comments on CMP for D Street/Valley Street/St. John work this summer

Tue, Jun 11, 2019 at 3:03 PM

Maine Medical Center Parking Garage		St. John Street - Utilities Work Zone Traffic Control Plan		FIGURE 1		
Shaw Brothers Construction, Inc. 341 Mosher Road, P.O. Box 69 Gorham, Maine 04038 (207) 839-2552		DRAWN:	M.E.		DATE:	3/5/19
		DESIGNED:	-		SCALE:	1"=125'
		CHECKED:	-		FILE:	-
		FILE LOC:	-

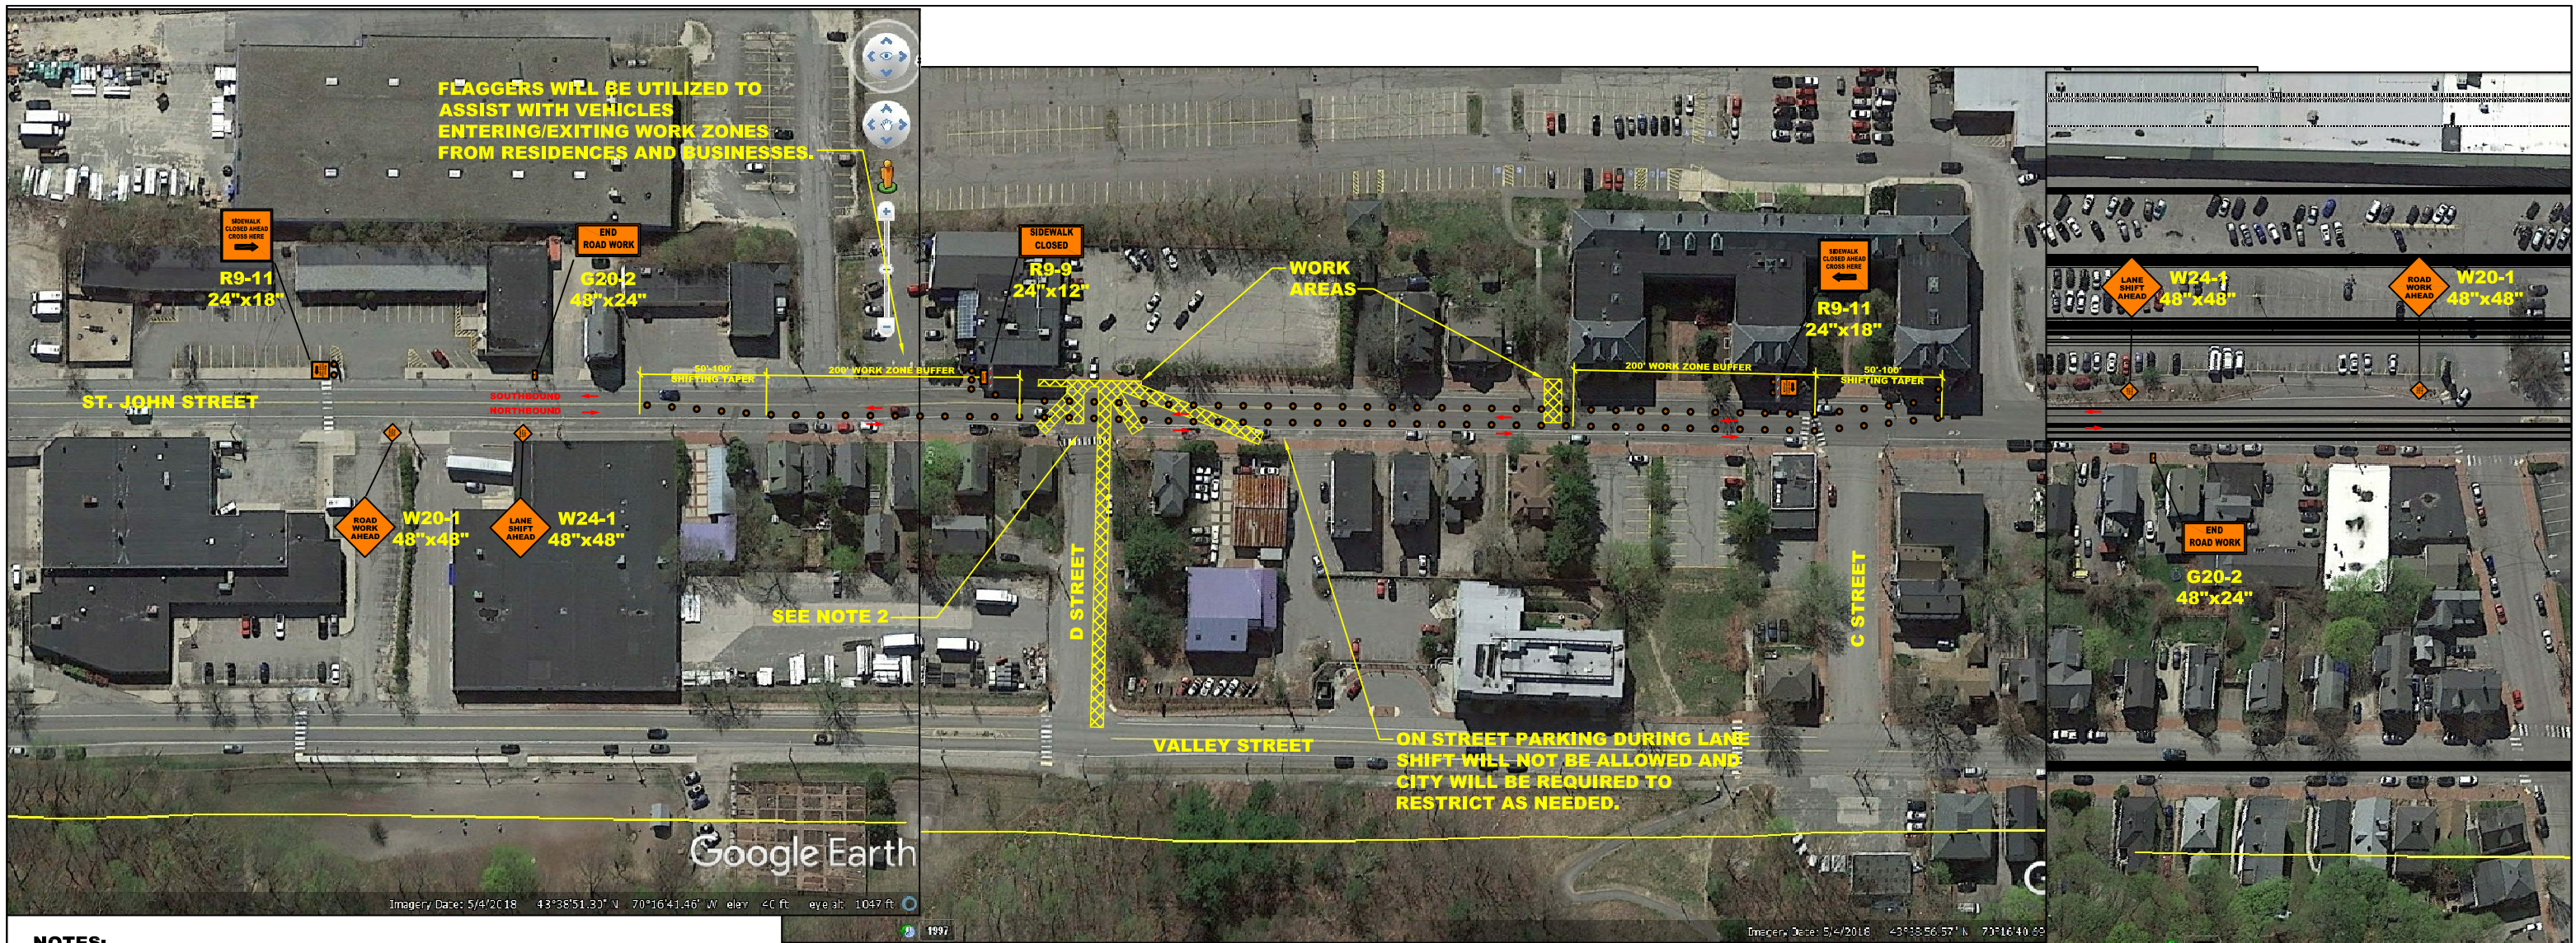
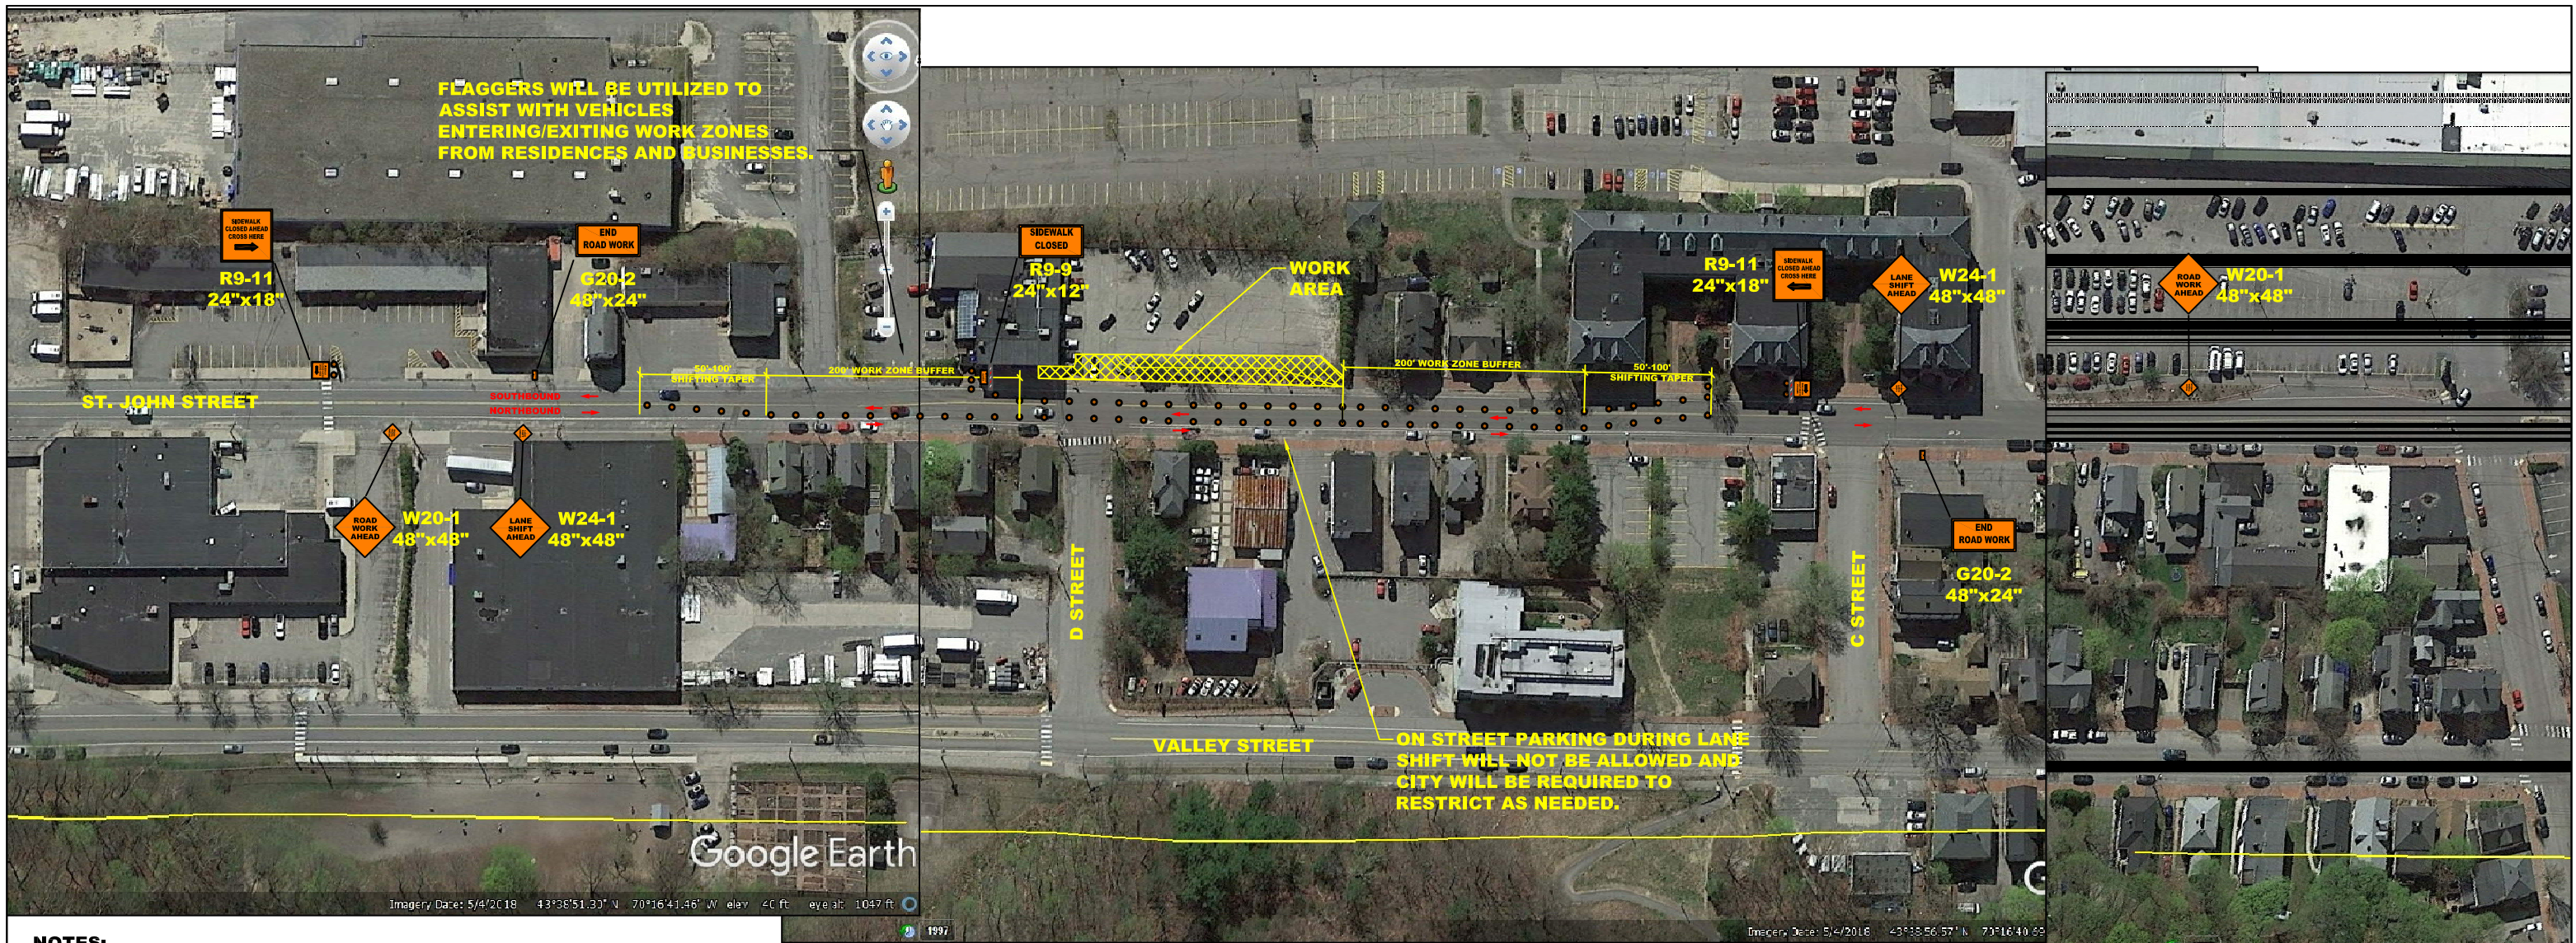
These spot grades are helpful, but I recommend they use a 7' tipdown between the existing inlet stone and the driveway instead of the 4', as proposed. With only 4' of transition, the slope exceeds 12%. Based on the google street view, it looks like there may already be a 7' tipdown here that's in decent shape.
